MEMORANDUM

TO: Molly Casto
FROM: Dan Goyette, PE, and Lauren Swett, EIT
DATE: January 28, 2008
RE: Estates of Longfellow Inn

Woodard & Curran has reviewed the response to comments provided for The Estates of Longfellow Inn. The project proposes to renovate and add to an existing multifamily residential building located at 130 Eastern Promenade in Portland. The garage for the existing building will be demolished and replaced with paved parking, and an expansion will be added to the building to provide room for seven units.

DRAWING
D3

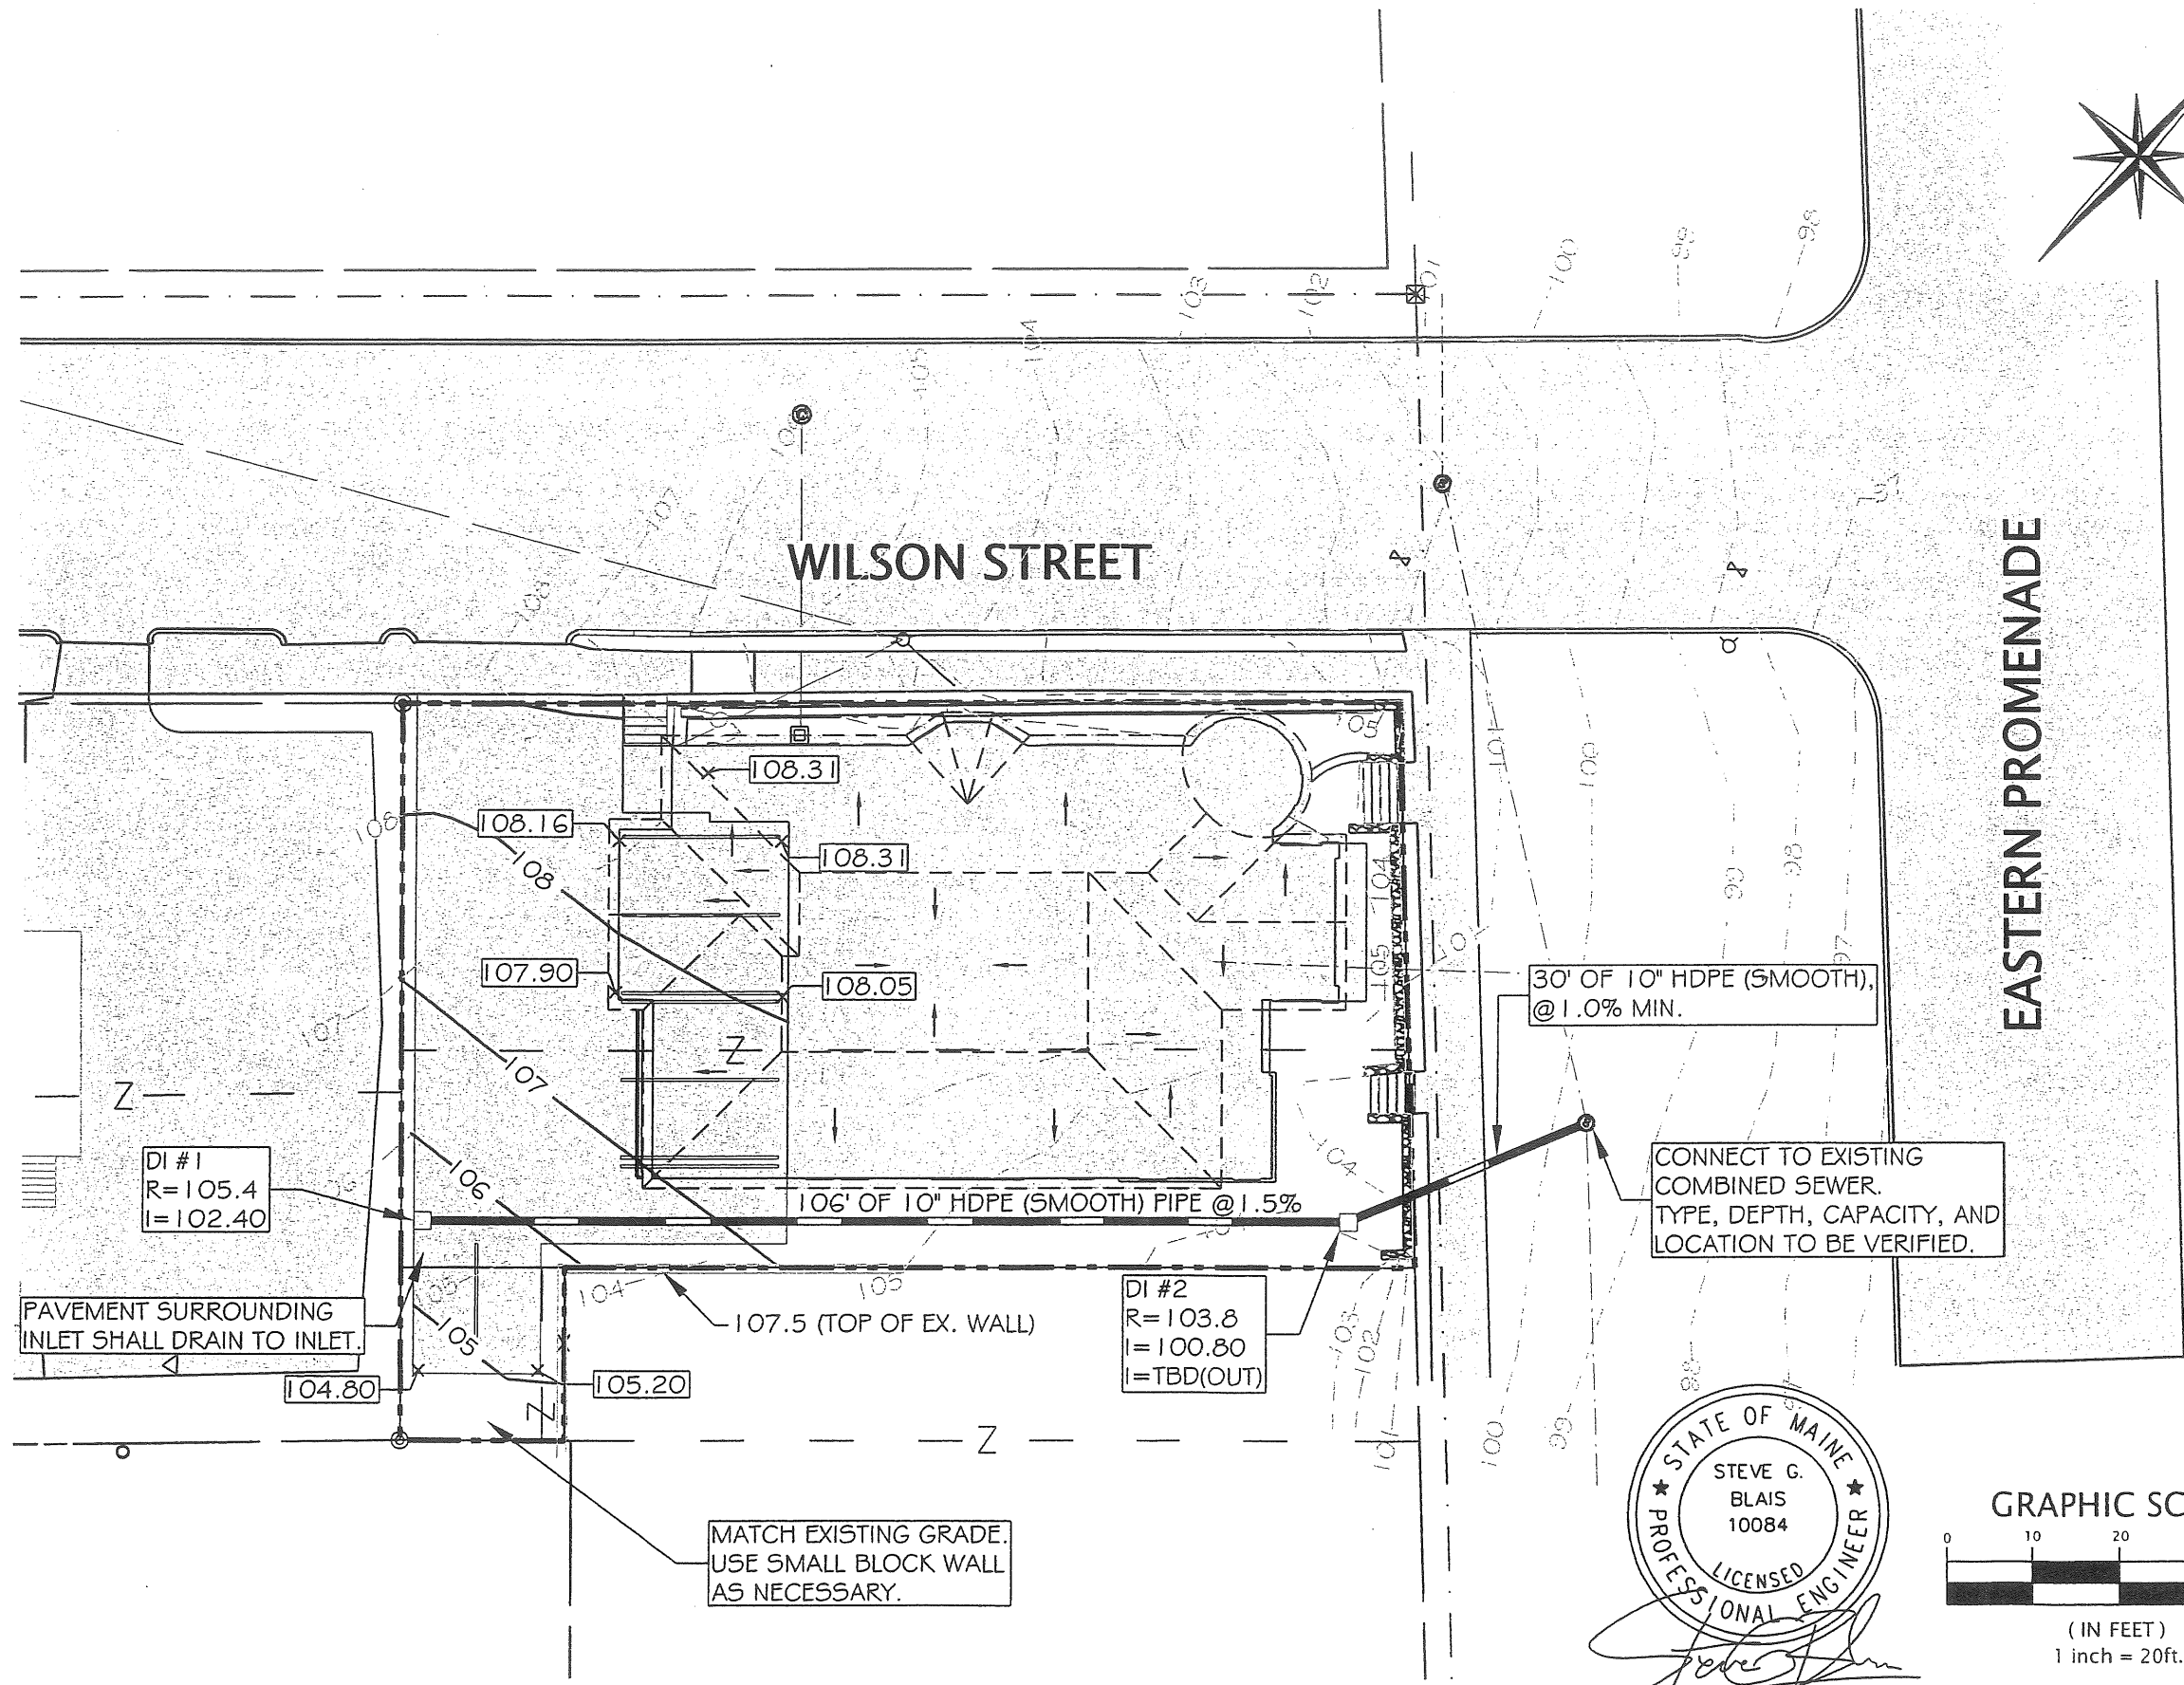
- All plan sheets must be stamped and signed by a professional engineer.
- The utilities detail sheet includes catch basin and casco trap details. The casco trap should also be included on the catch basin detail to show proper installation.
- The PVC line directing surface and roof drainage to the combined sewer line should connect directly into the combined sewer line and not into the existing sewer manhole.
- The boundary survey is in compliance with City of Portland standards.
